Submission re MP 08 0191 Port Kembla Demolition Project

***Evacuation Management Plan: 200M Stack Demolition
Revision 1: 9 October 20134.***

Site Location Plan

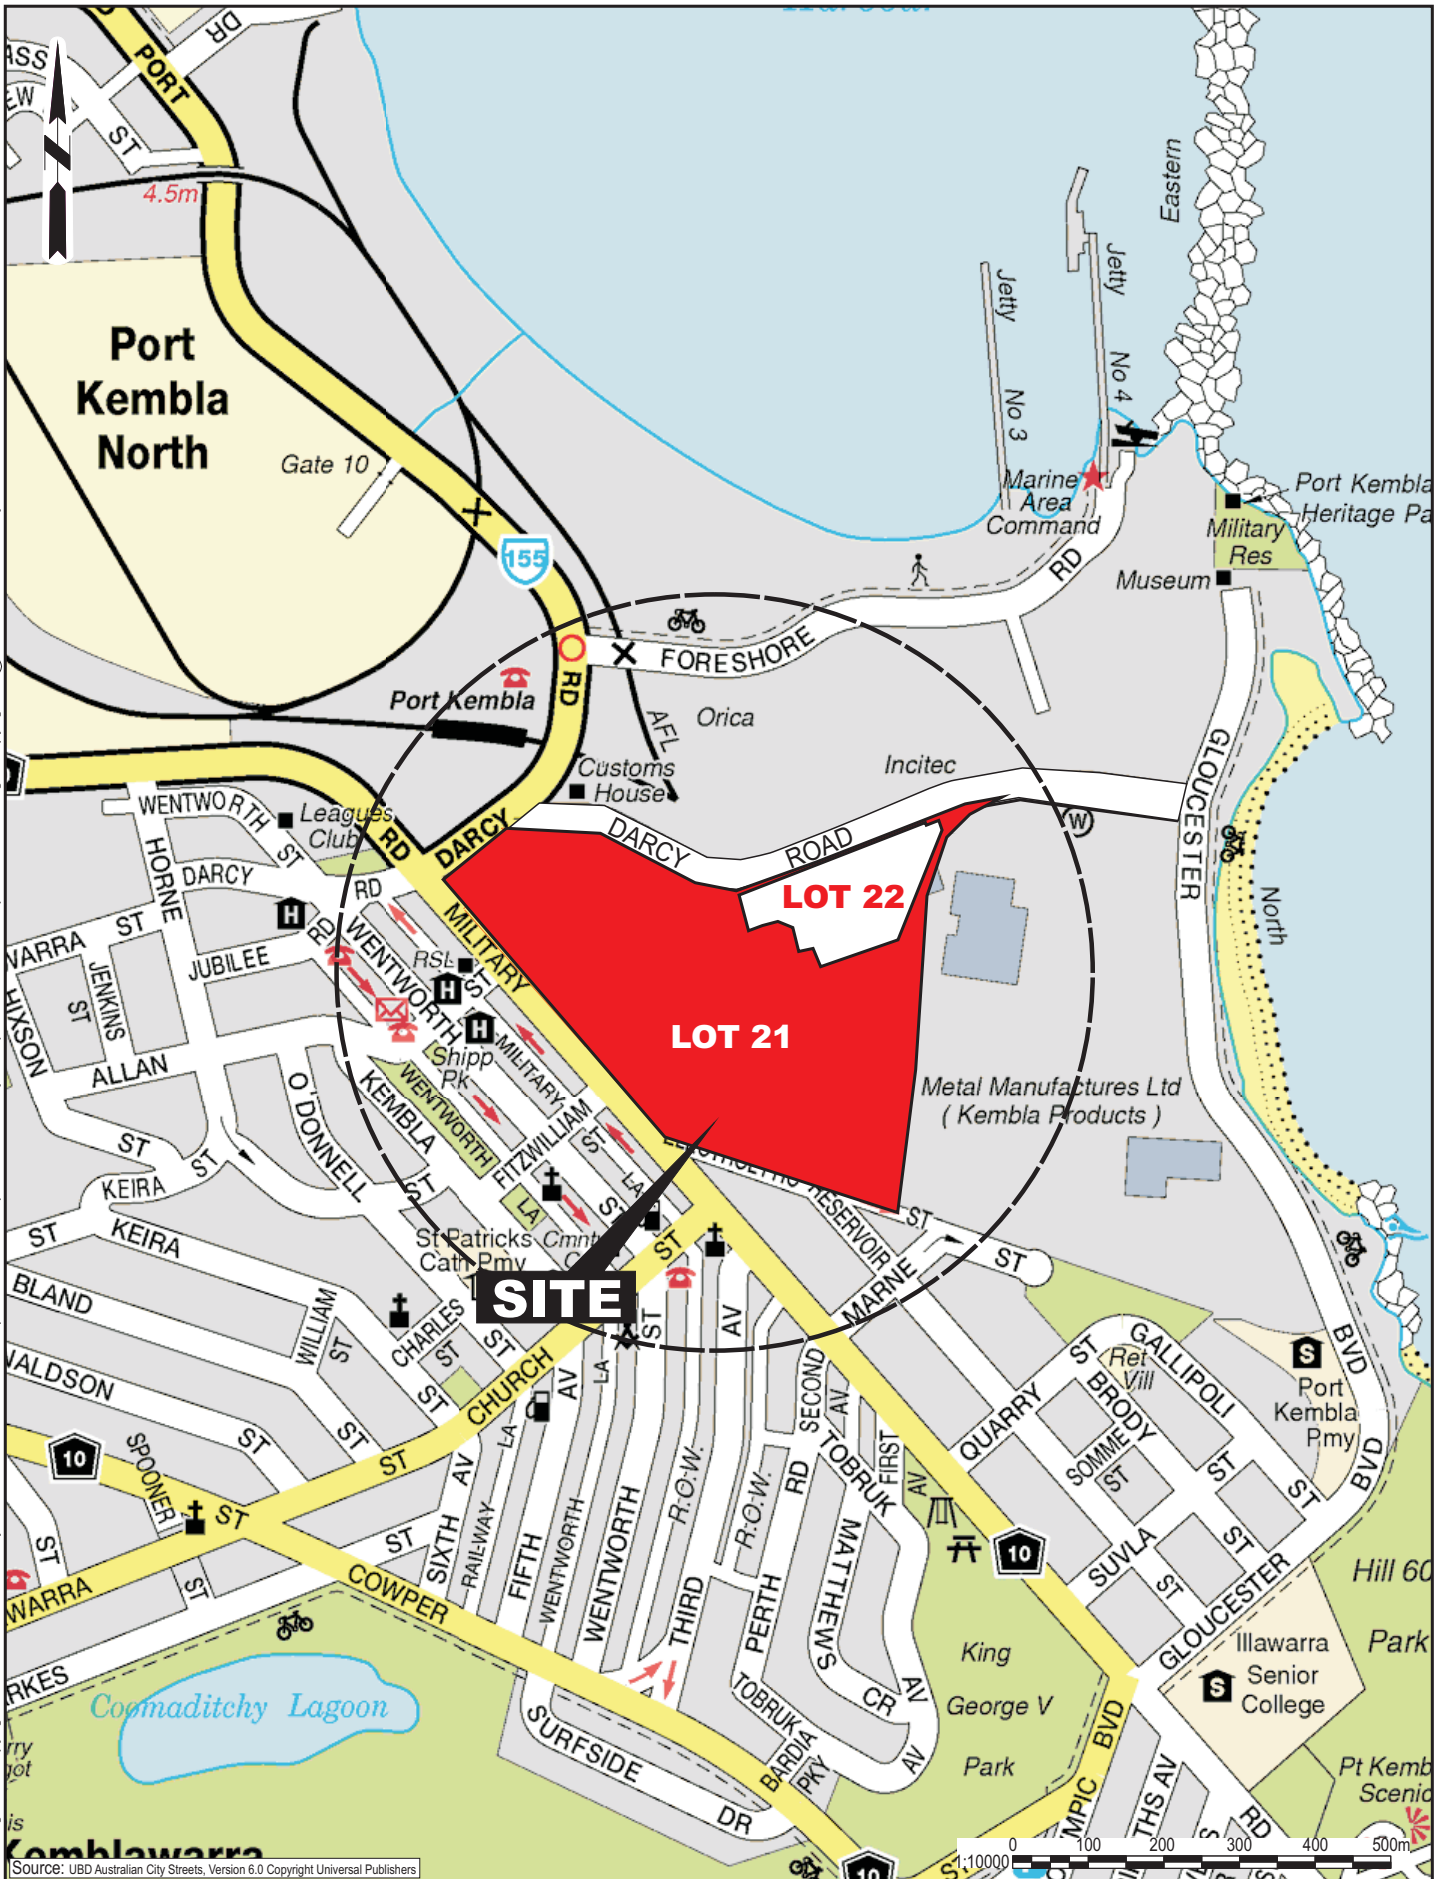
INCORRECT
MAPS

WITH
SYDNEY PLACE
MISSING
+ OTHER ERRORS

Traffic Management Information

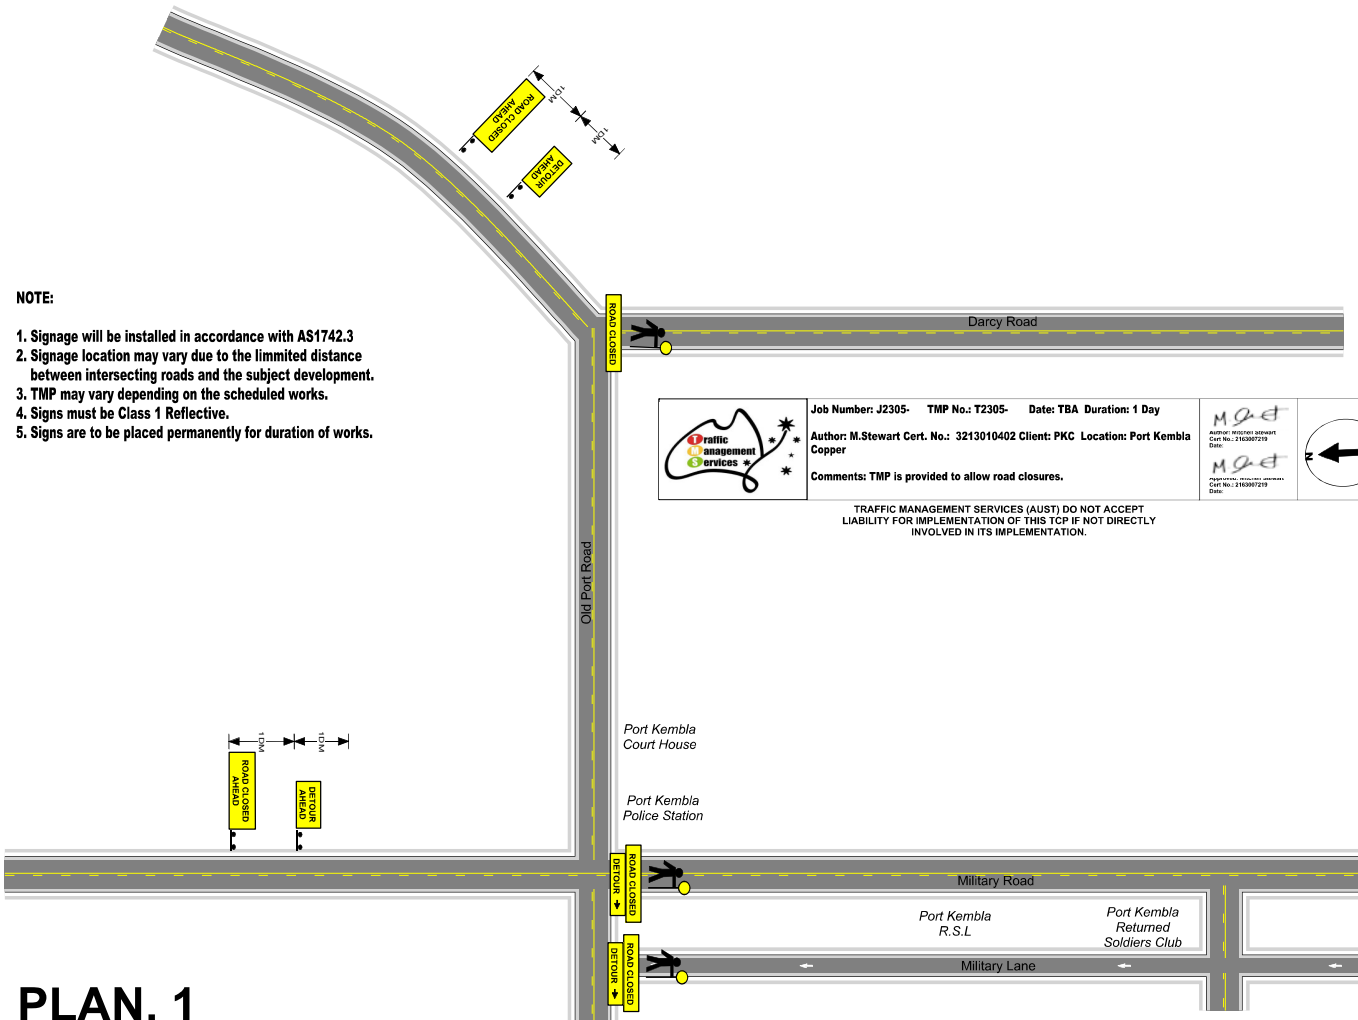
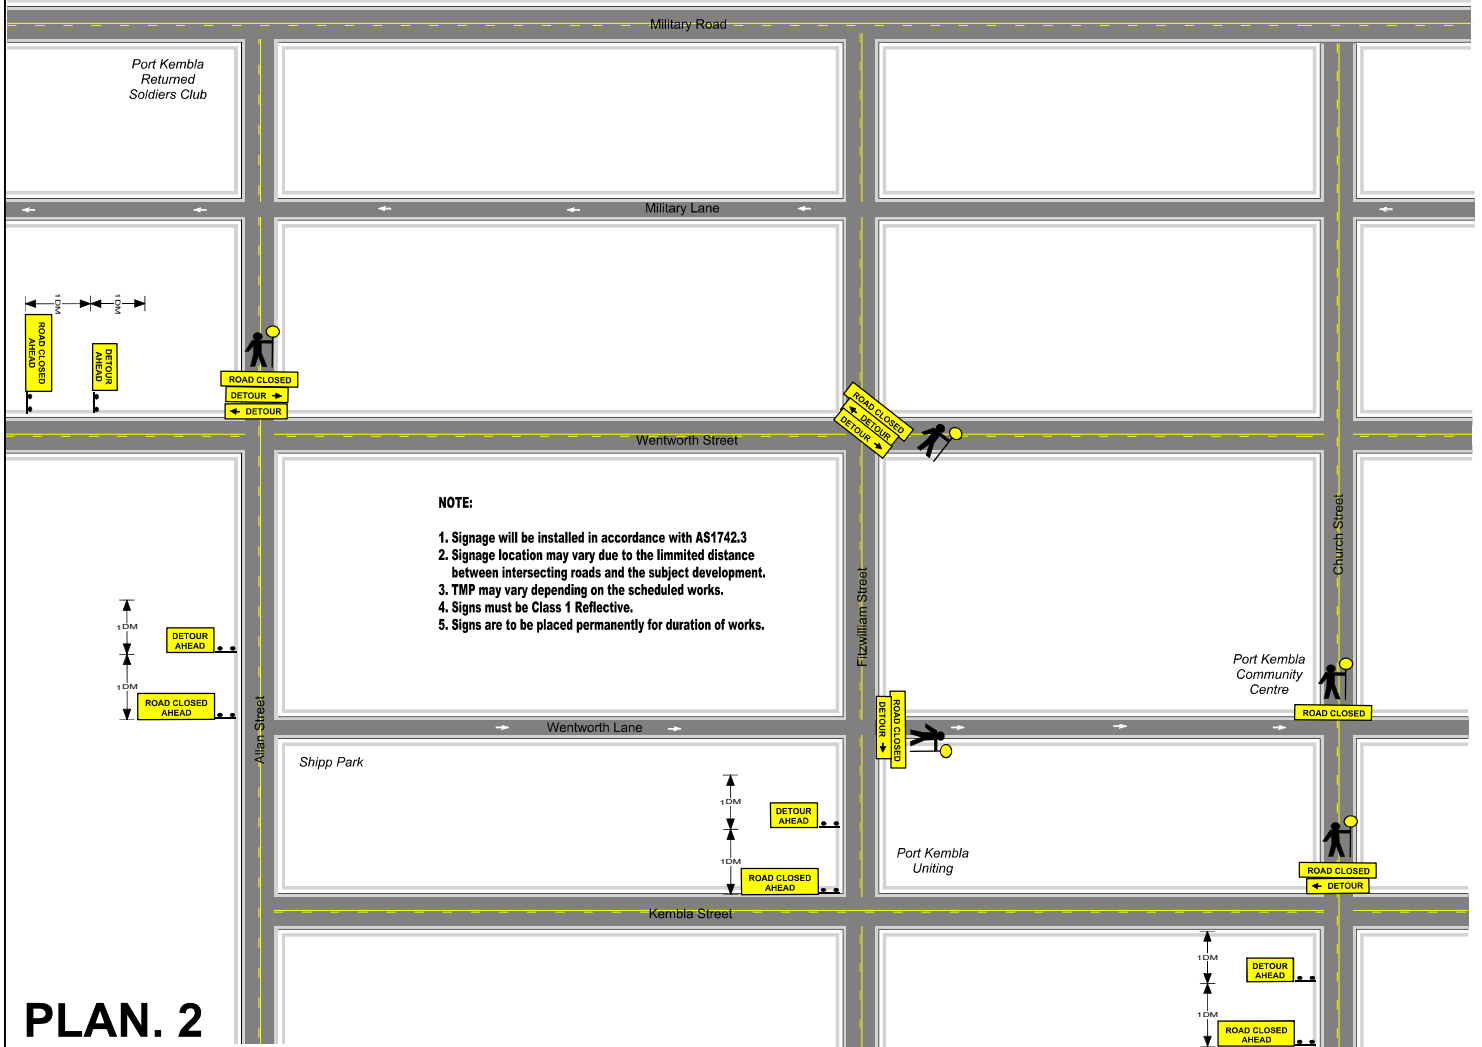
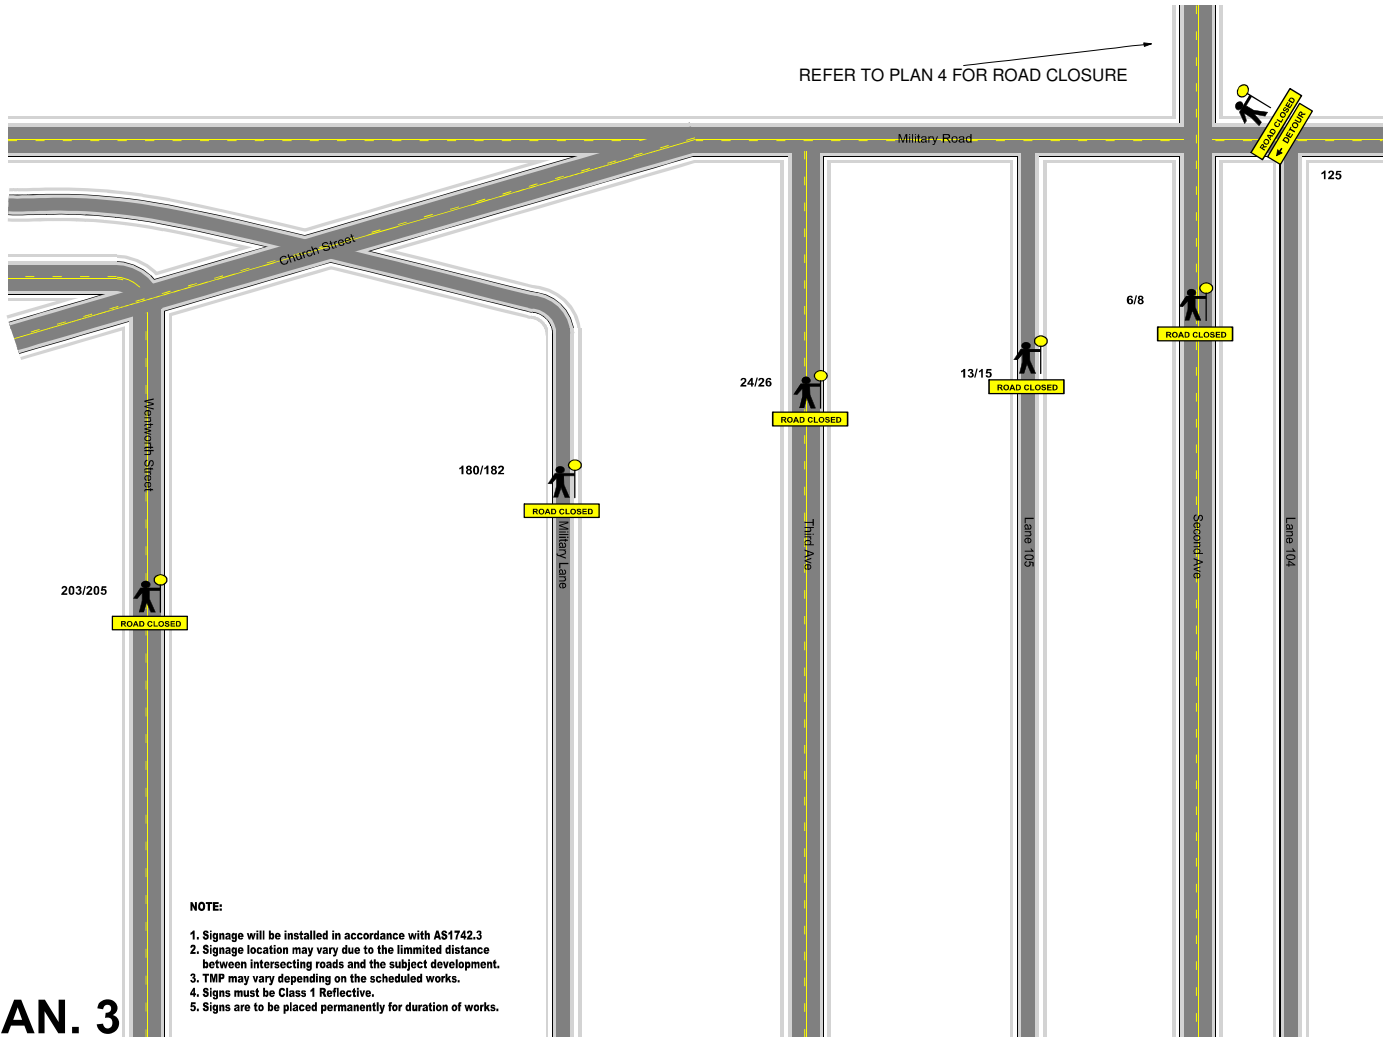
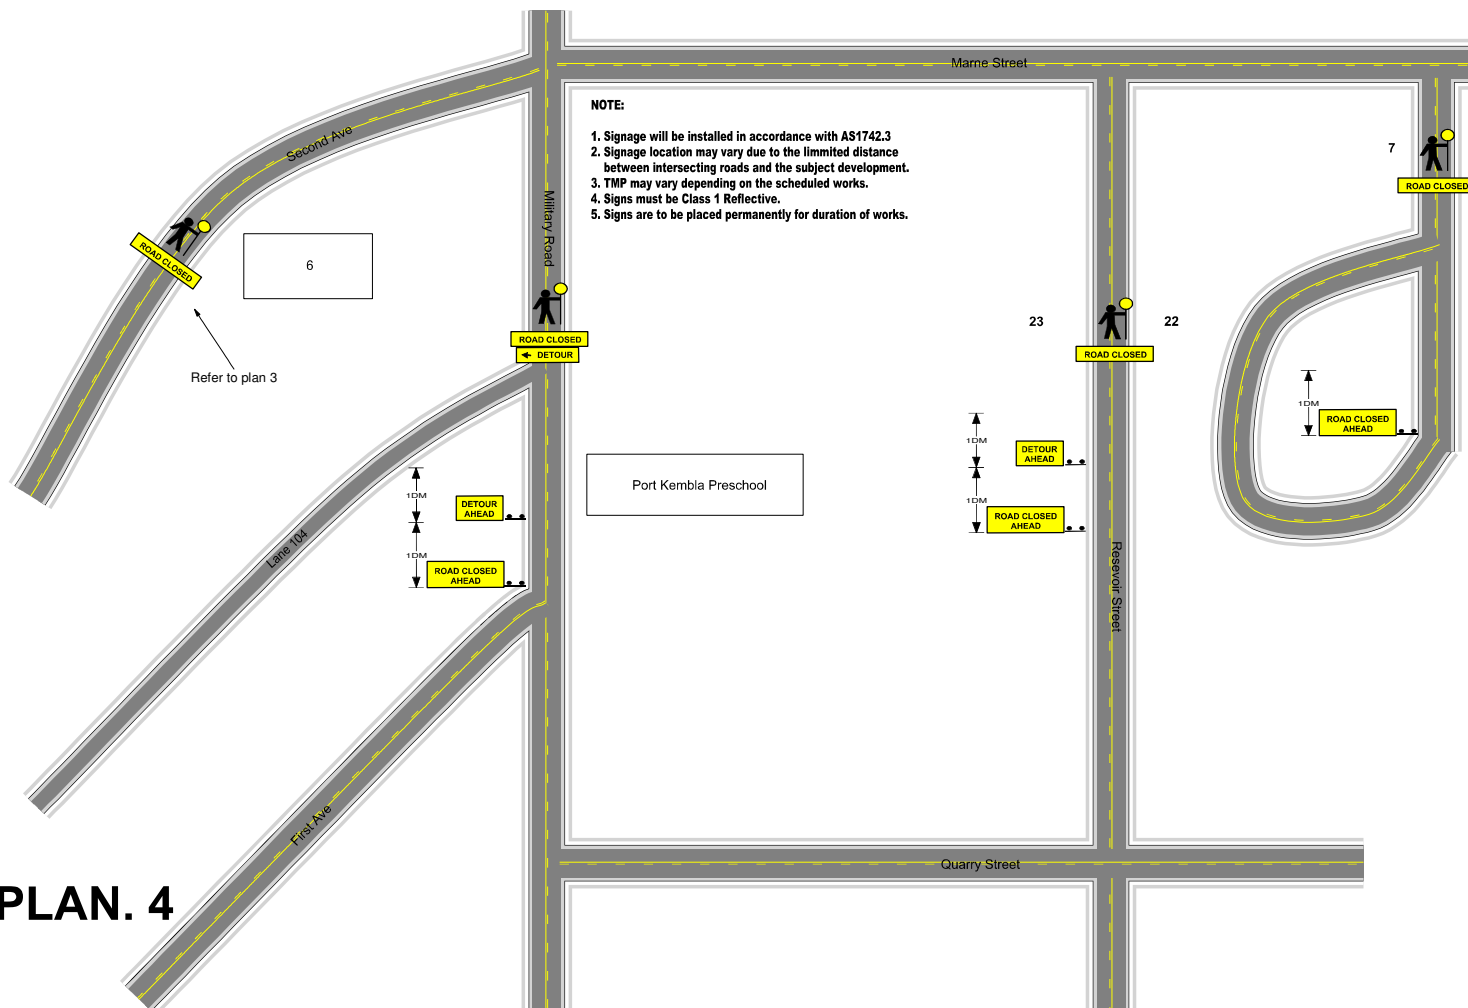
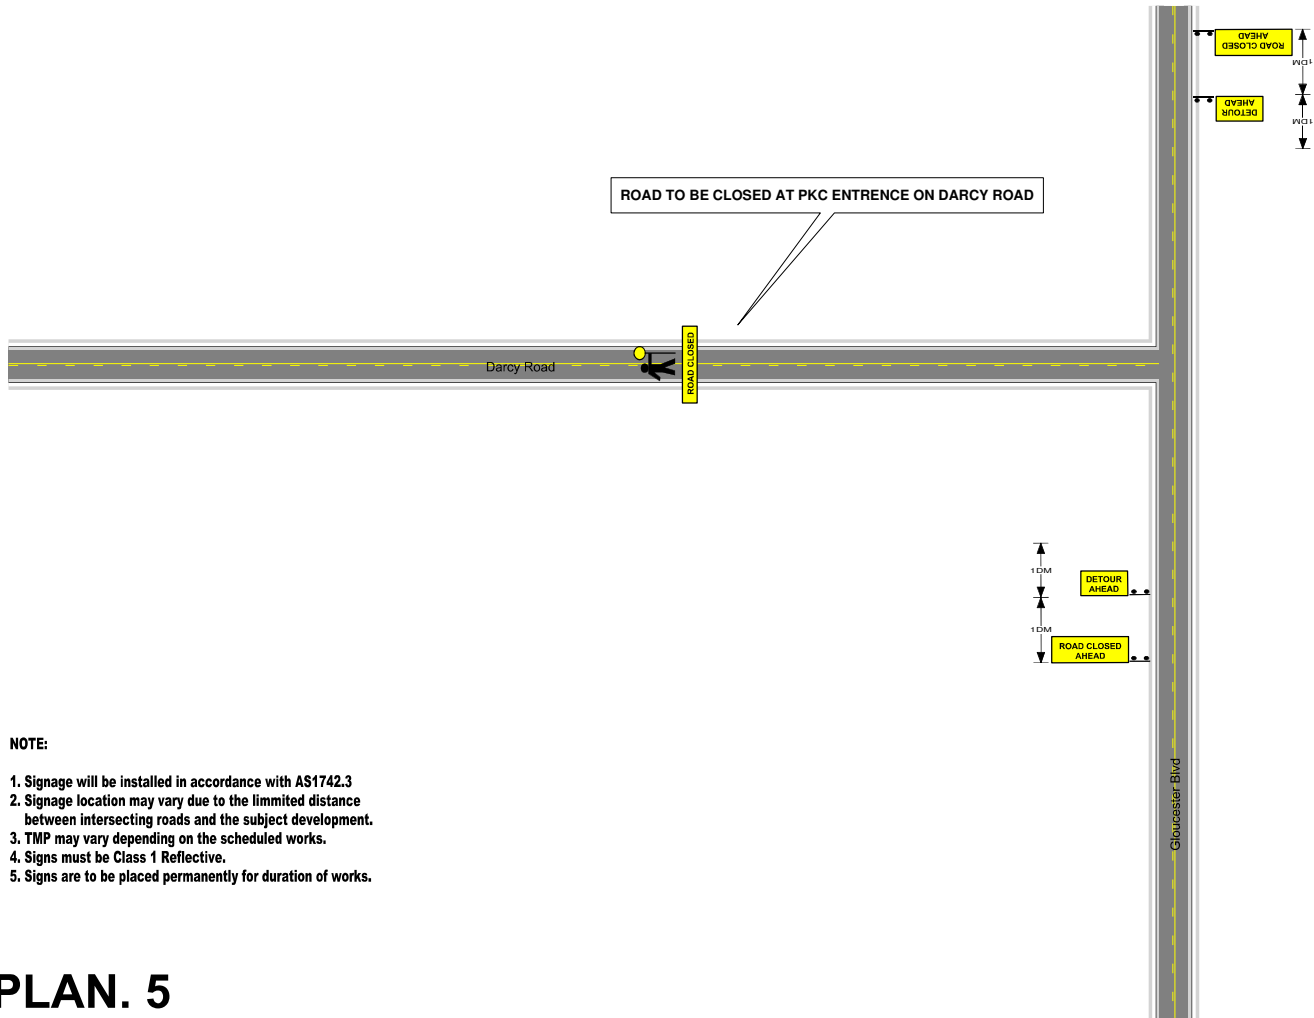
Many errors appear in the maps being used with roads inserted that have never existed and other roads that are relevant or missing and should be there.

I live at _____ and I will have to access _____ property via Wentworth Lane and Sydney Place (when Church Street is closed). However the maps don't even show Sydney Place and there are no DETOUR signs marked to close the southern end of Wentworth Lane. This leaves my property open to easy public access even though I am in the Exclusion Zone and I will be required to leave my property for safety reasons. If the lane does eventually get closed then it can still easily be accessed by residents in Fifth Avenue (who are not in the EZ) using their rear gates.

Will these maps be corrected and information used be reviewed? I am happy to share my 69 years of local knowledge to assist.

- F. Not all access roads are shown on their maps in their documents supplied on 25th October and therefore not all access to the Exclusion Zone is shown to be blocked.

THIS IS NOT
A T INTERSECTION

WENTWORTH LANE STH
NO SHOW OR WITH
ANY ROAD CLOSURE

THIS LANE HAS
NEVER EXISTED

THESE
ARE HANDLOCKED
WITH NO DETOUR

BOTH
ARE IN TOTALLY
DIFFERENT STREETS

SYDNEY PLACE
NOT ON MAP

BUT IS ACCESS
IN EXCLUSION ZONE

• WHERE IS DETOUR? TO BE

NOT ON THIS
MAP EITHER
